Appeal Decision

Appeal Ref: APP/T2350/D/23/3319827

77 Ribchester Road, Wilpshire, Lancashire BB1 9HT

- The appeal is made under section 78 of the Town and Country Planning Act 1990 against a refusal to grant planning permission.
- The appeal is made by Mr Steve Grunshaw against the decision of Ribble Valley Borough Council.
- The application Ref 3/2022/1073, dated 9 November 2022, was refused by notice dated 27 February 2023.
- The development proposed is a two storey side and single storey rear extension to a semi detached dwelling.

1094/RRC/PL1 | **C**

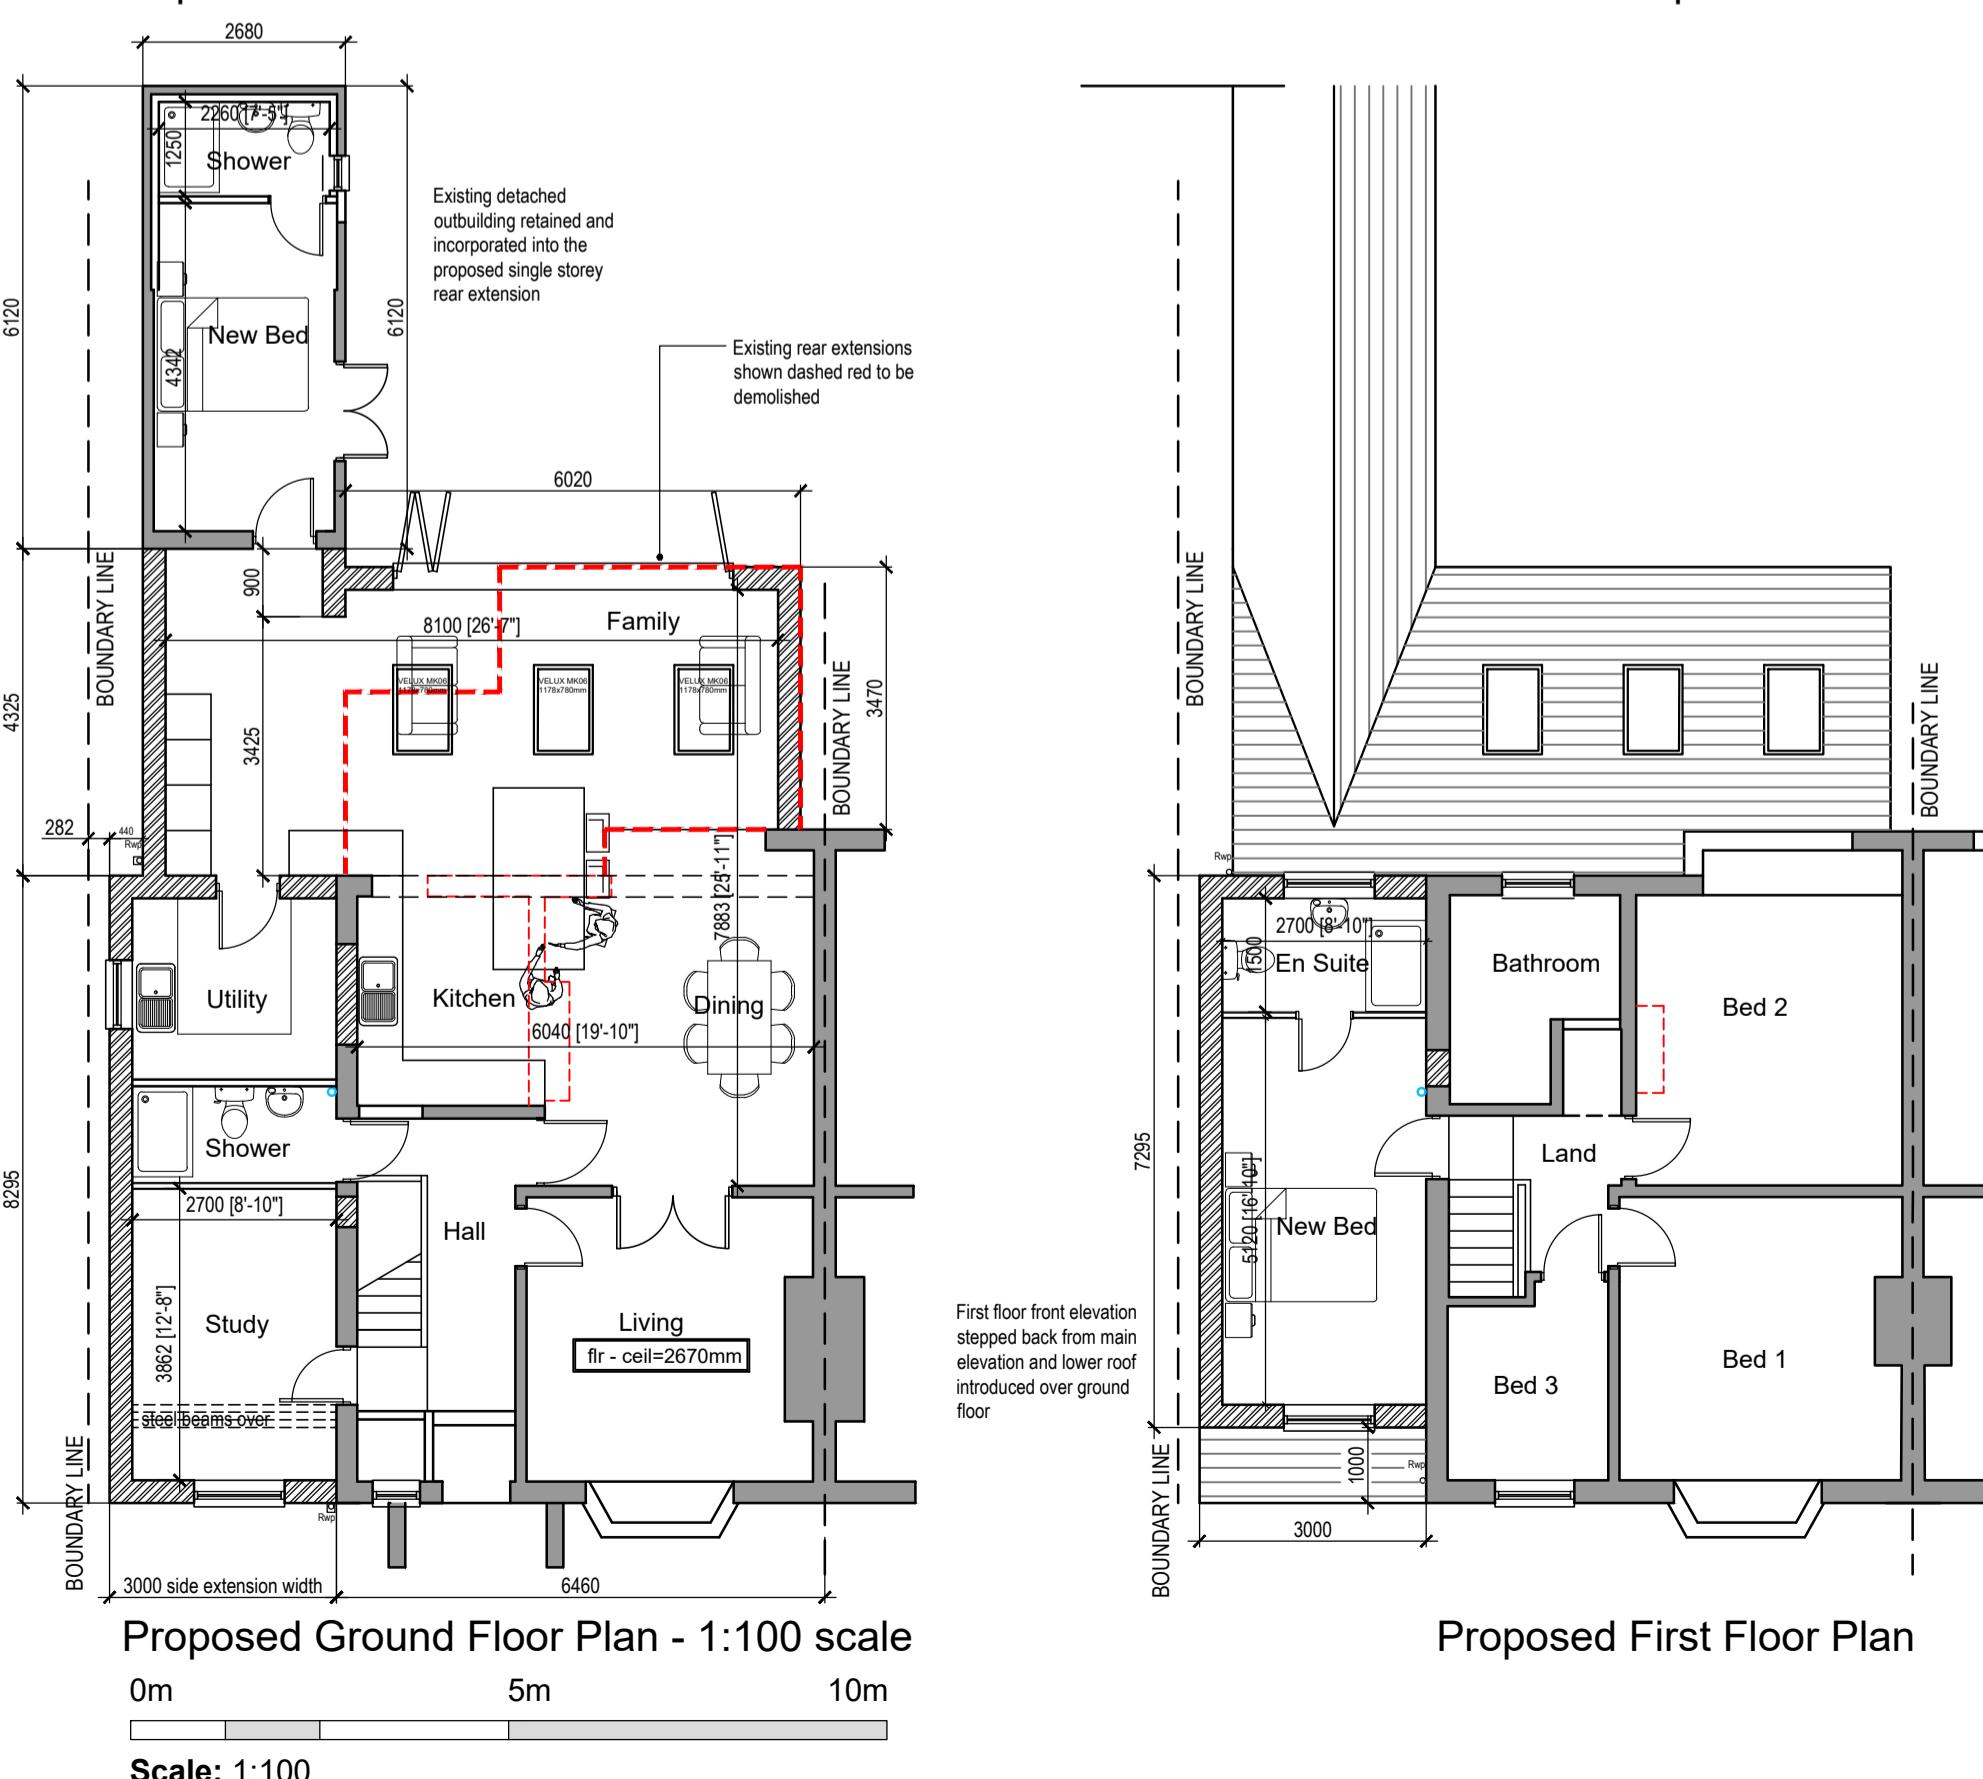
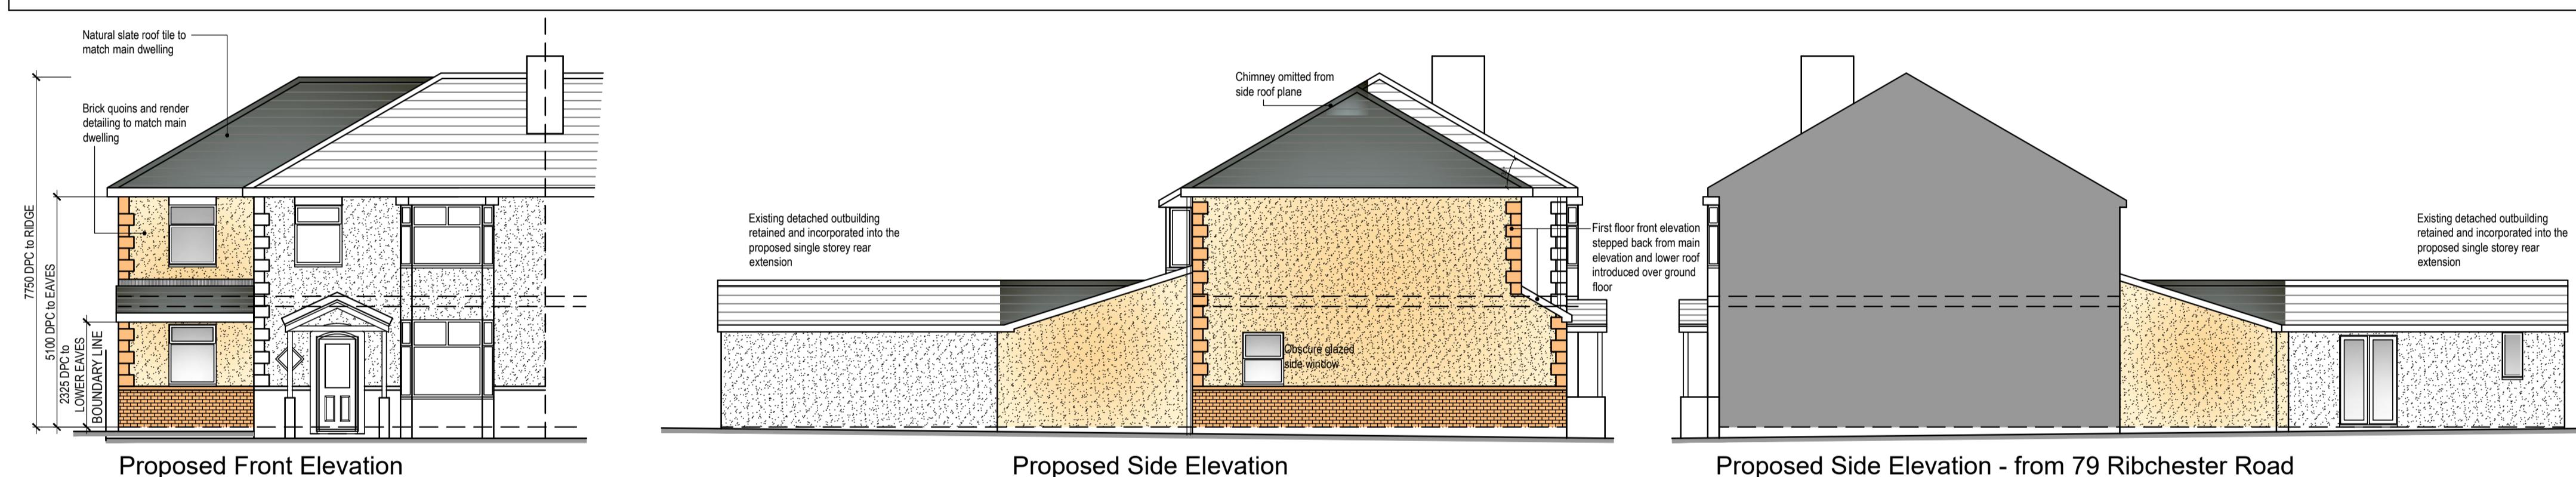
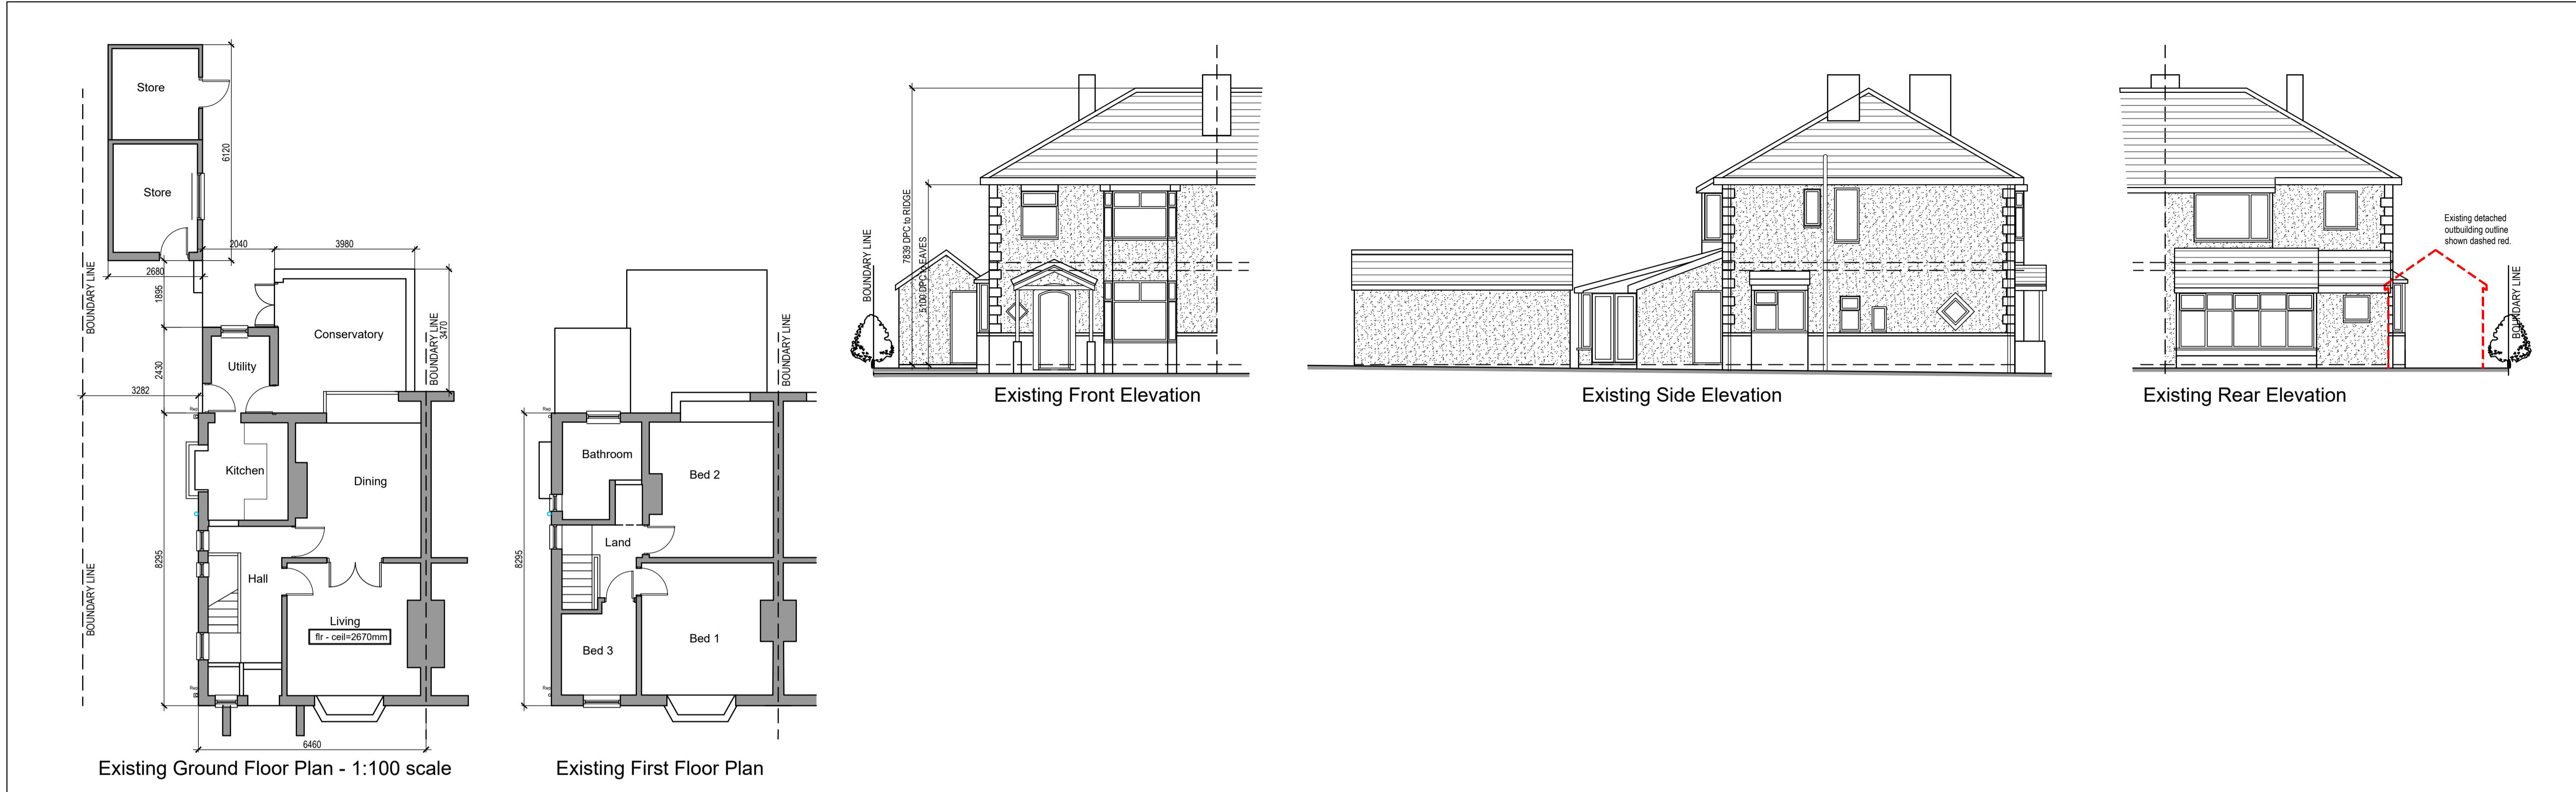
3. The two-storey part of the proposal would be situated to the side of the existing two storey section of the building and would extend close to the common boundary with No. 75. This neighbouring property has a number of windows that face the appeal site, including a side-facing window that the Council has identified is the only source of daylight to a habitable room. Given the proposal would bring a two-storey addition closer to the side elevation of No. 75, it would result in a harmful loss of daylight and an unacceptable overbearing impact.

4. The two-storey extension would have a single storey element to the rear that would be adjoined to an existing outbuilding. This would present an elongated side elevation close to the common boundary with No. 75. However, given the height of the single storey element of the proposal, and the existing boundary treatment that I was able to see at the time of my visit, as well as outbuildings in No. 75's garden, I do not consider that the single storey element of the proposed development would result in an undue loss of outlook.

5. Nevertheless, I conclude that the proposal would have an unacceptable harmful impact on the living conditions of neighbouring occupiers at 75 Ribchester Road with regard to daylight and outlook. As such, it would conflict with Policy DMG1

7. The two-storey side extension has been amended so that it would be setback at first floor level from the front elevation of the existing dwelling and have a lower roof ridgeline. Whilst this would differentiate the extension from the existing host property, it would nevertheless introduce built form close to the common side boundary with No. 75. Although the neighbouring property has not been extended to the side, this development would alter the regular pattern of spaces between the houses, and the closing of the gap could give rise to a terracing effect when seen along Ribchester Road. The Council has raised concerns on views of the proposal from Showley Court. However, whilst the development would be visible from public vantage points to the rear of the appeal site, given that much of the development is single storey, it would not appear over dominant in such views.

9. I conclude that the proposal would have an unacceptable adverse effect on the character and appearance of the host property and the area. As such, it would conflict with Policy DMG1 of the Core Strategy, which seeks, amongst other matters, a high standard of building design and development which considers visual appearance and the relationship to surroundings. It would also be contrary to Paragraph 130 of the Framework which seeks development that is sympathetic to local character.
